# The Design Review Panel

<b>Site</b>	Oxpens Wigginton, Banbury, Oxfordshire, OX15 4JZ
<b>Proposal</b>	Proposed Para 79 House
<b>Local Authority</b>	Cherwell District Council
<b>Applicant</b>	Virginia Sweetingham
<b>Agent</b>	Hughes Planning
<b>Architect</b>	Seymour-Smith Architects
<b>Landscape Architect</b>	Seed Landscape Design
<b>Review Date</b>	15 <sup>th</sup> November 2019

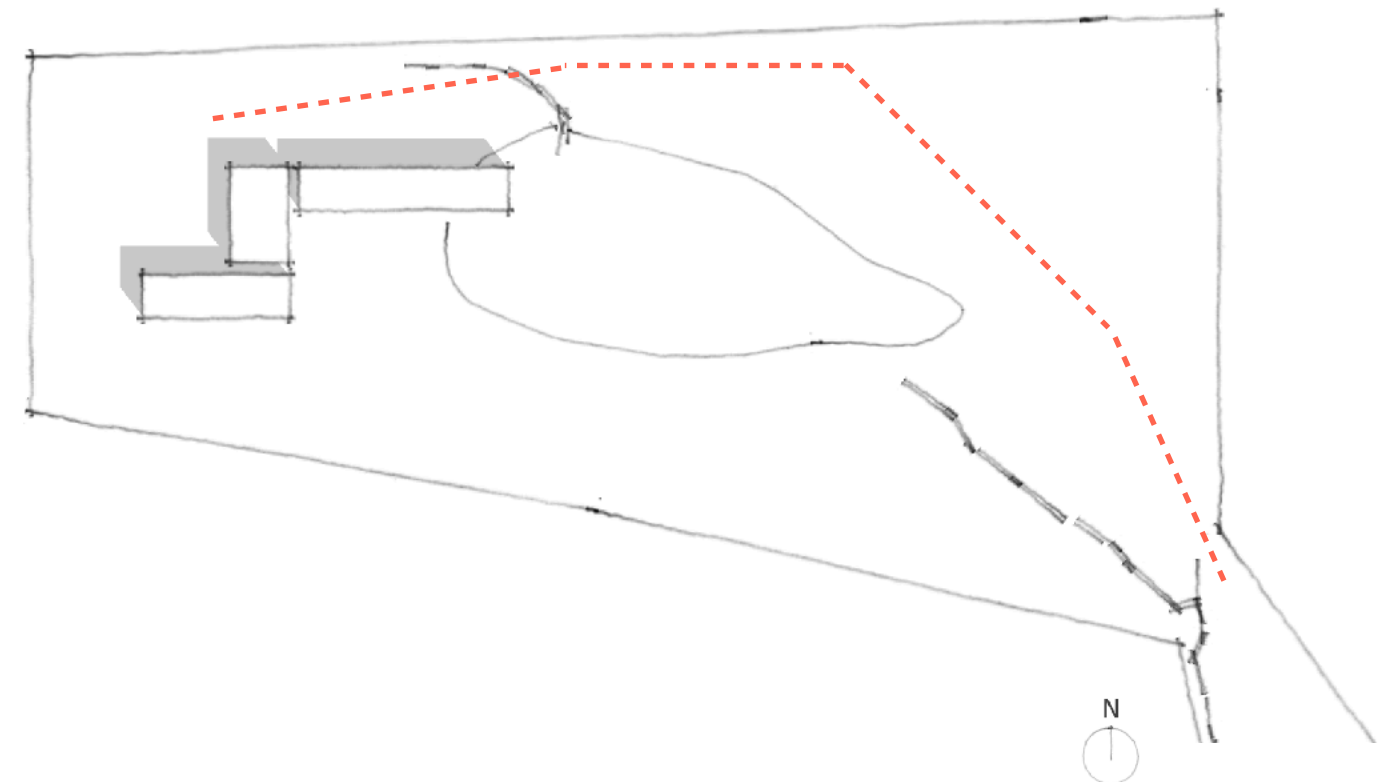
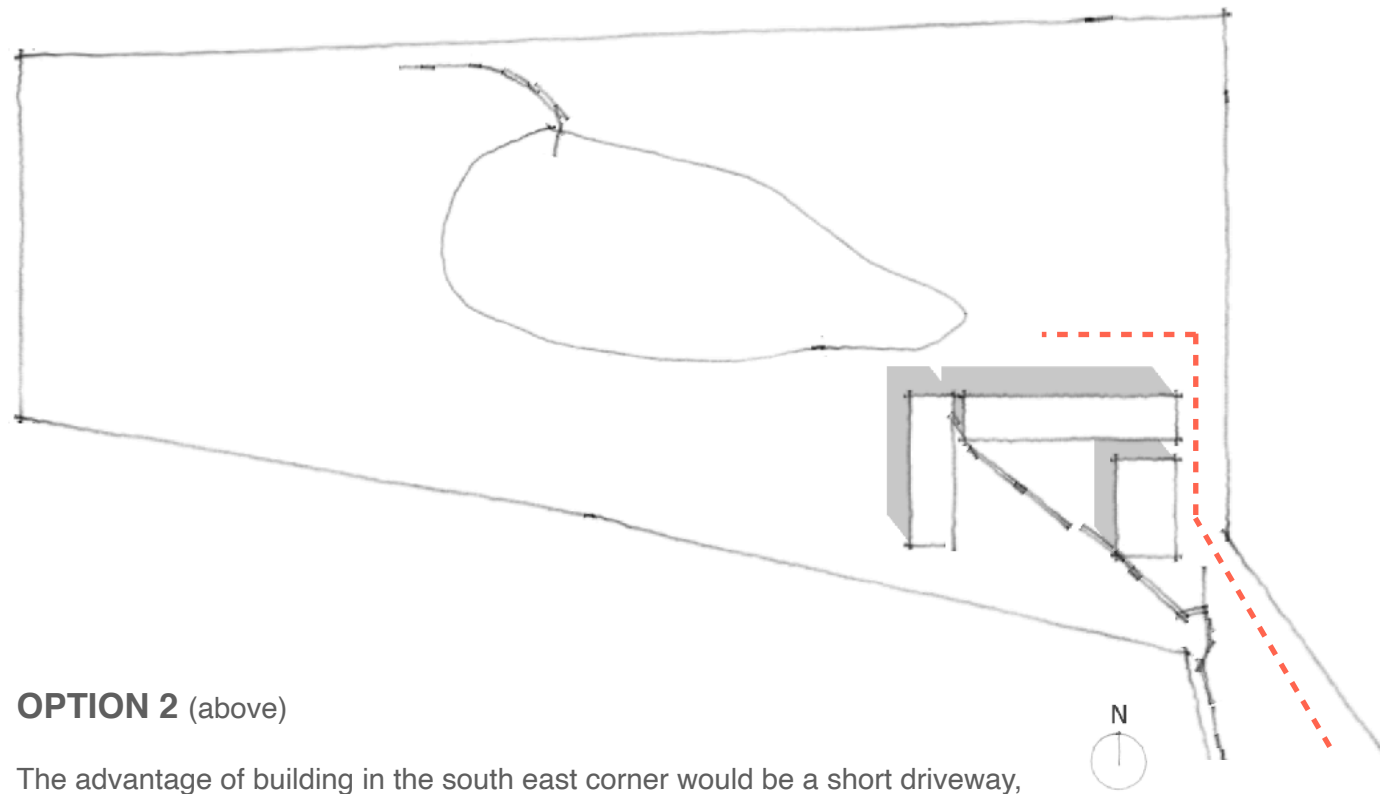
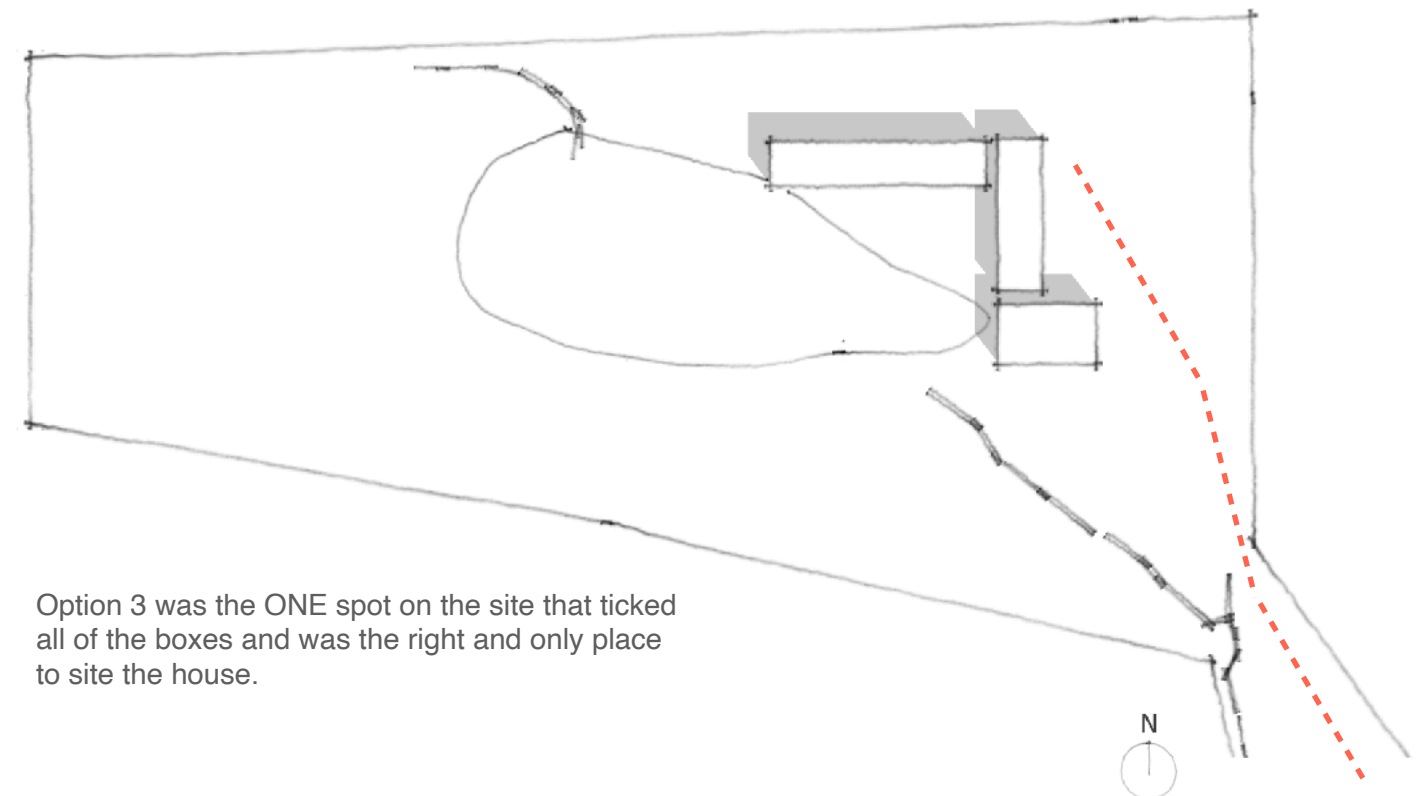
Architecturally, it is considered that the presentation given to the Panel was extremely clear and logical, notwithstanding this it is suggested that it may be helpful for any future presentation, or planning application, to more clearly demonstrate optioneering, in terms of siting of the proposed house. Furthermore, it is felt it would be beneficial for the design team to demonstrate that potential re-use of the barn has been considered as part of the above optioneering exercise, particularly as the proposed access passes so close to the existing barn. It is noted that the barn represents a very sheltered location within the site, which is reflected by the historic reasoning as to why a barn was built in this location, therefore it is suggested it may be helpful to include a clearer narrative as to why the current siting has been chosen. It may be beneficial for the proposals to more clearly explain how they may relate to the existing barn and also demonstrate that they will not damage its future potential.

PHOTOGRAPHS OF MODEL  
Presented to second Design Review Panel  
February 2020

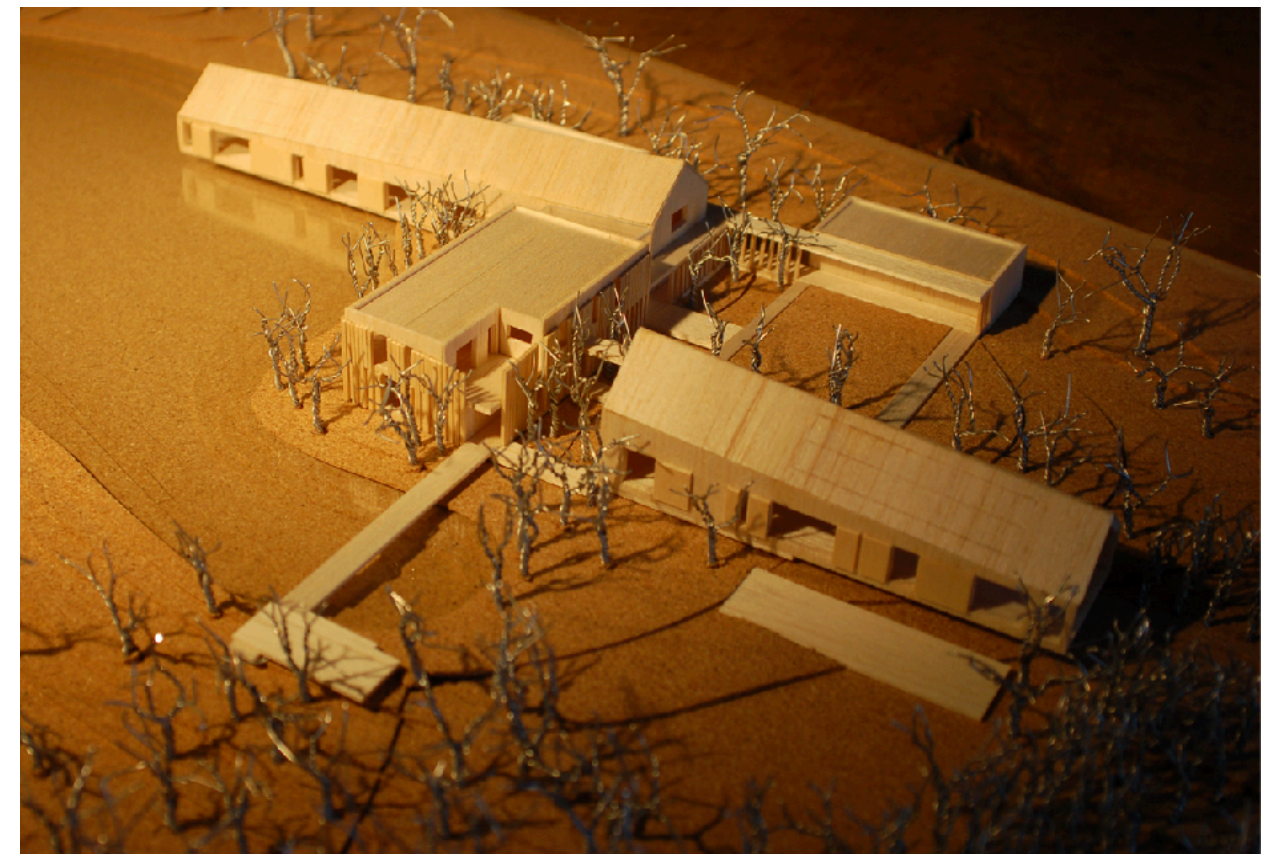
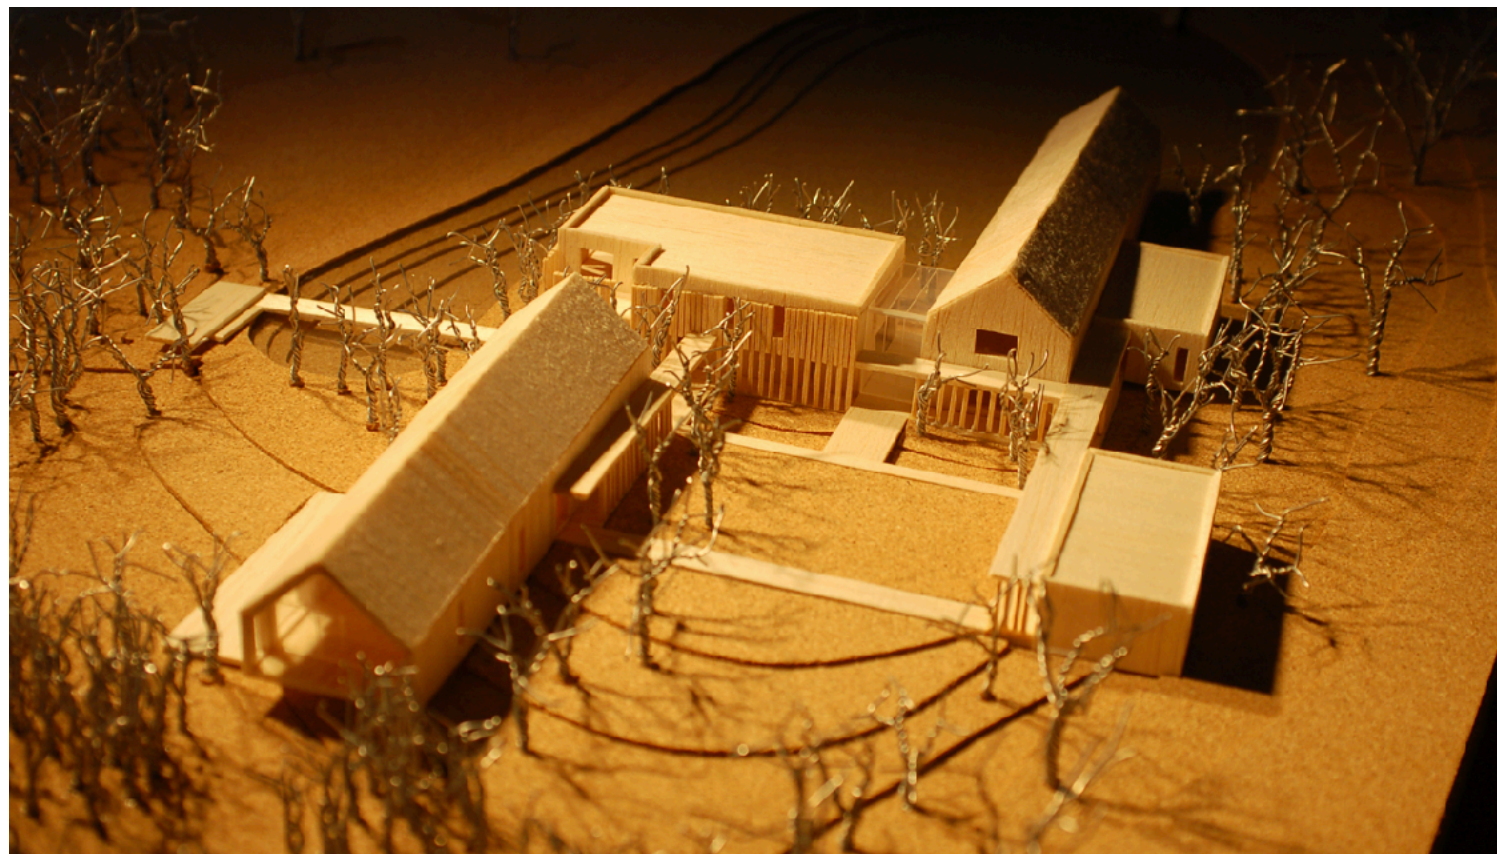
Generally, the Panel is supportive of the proposed built form and the relationship between elements. Notwithstanding this, there is a concern regarding the central element, which it is considered feels static; it is felt that the proportions of the central element are less successful or refined and that this central element is less dynamic than the other two elements. The intention to create a contrast between the

elements is noted and supported, however it is suggested that there may be an opportunity for this contrast to be further emphasized.
